## **Response to Applicant's Submission "Additional Submission - 9.15 Alternative Wood Lane Junction Options Appraisal"**

In its Deadline 4 submission "*Written summaries of oral submissions made at hearings w/c 1 November 2021*" (Planning Inspectorate Reference REP4-20) Norfolk County Council advised that it would comment on the technical merits of the proposed junction put forward by Mr Meynell on behalf of Berry Hall Estate. It also stated that, since it was confirmed at the hearings that Berry Hall Estate would be submitting revised proposals at Deadline 5, the County Council proposed to provide these technical comments on the revised proposals that are to be tabled. The County Council notes that Berry Hall Estate did not submit its proposal for Deadline 5 and as a result a technical assessment has not been undertaken.

Figure 2-3: Wood Lane Junction Alternative 42

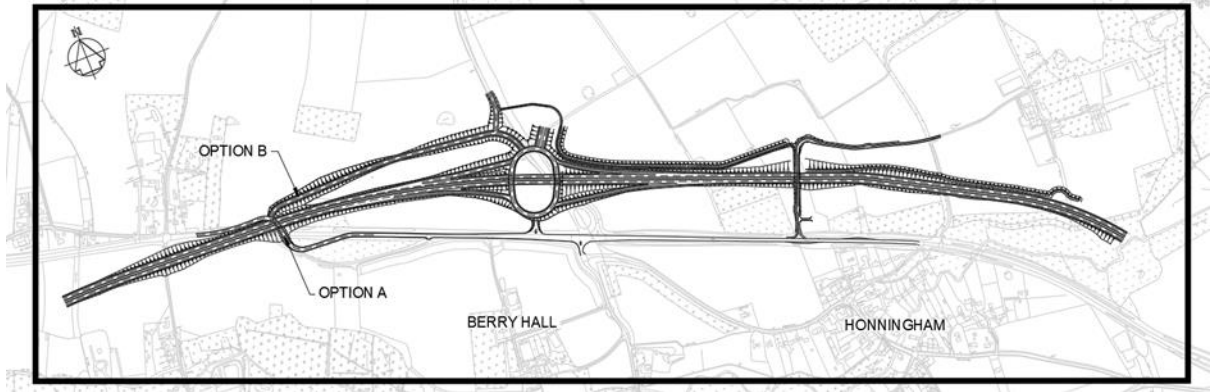
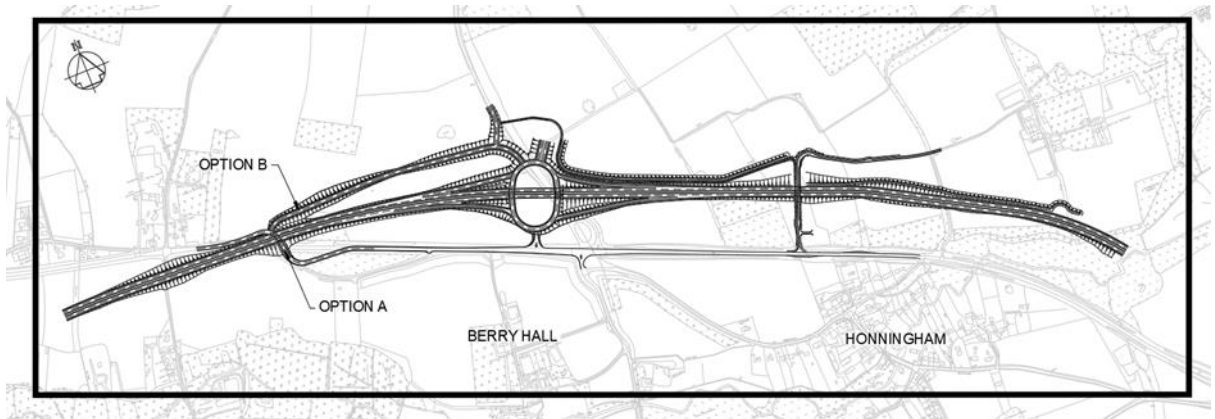
Whilst the County Council has not undertaken a technical assessment to confirm the Applicant's conclusions, it has concerns about any alternative option that would reduce road safety or increase maintenance requirements. With this in mind, both Alternative 1(A and B) and Alternative 2(A and B) would appear to increase the maintenance requirements by introducing an additional length of de-trunked road and a junction (the existing A47 and Wood Lane junction) into the local highway network. In the case of Alternatives 1A and 2A a new underpass of the A47 would also be introduced. Similarly, introducing an additional junction into the local highway network could provide an additional area of risk, although as identified above no technical assessment of this has been undertaken.

The Applicant's submission concludes that, having reviewed the alternative options, the current Scheme design remains the preferred Wood Lane junction design option with regards location and layout. The County Council has discussed the current Scheme design with the Applicant during its development and supports its approach of using the UK DMRB as a framework for the design of the sideroads. An independent assessment of its operational capacity has also been undertaken by the County Council's Norwich Western Link (NWL) delivery team. As a result, the County Council can confirm that it supports the Applicant's proposal for this junction.
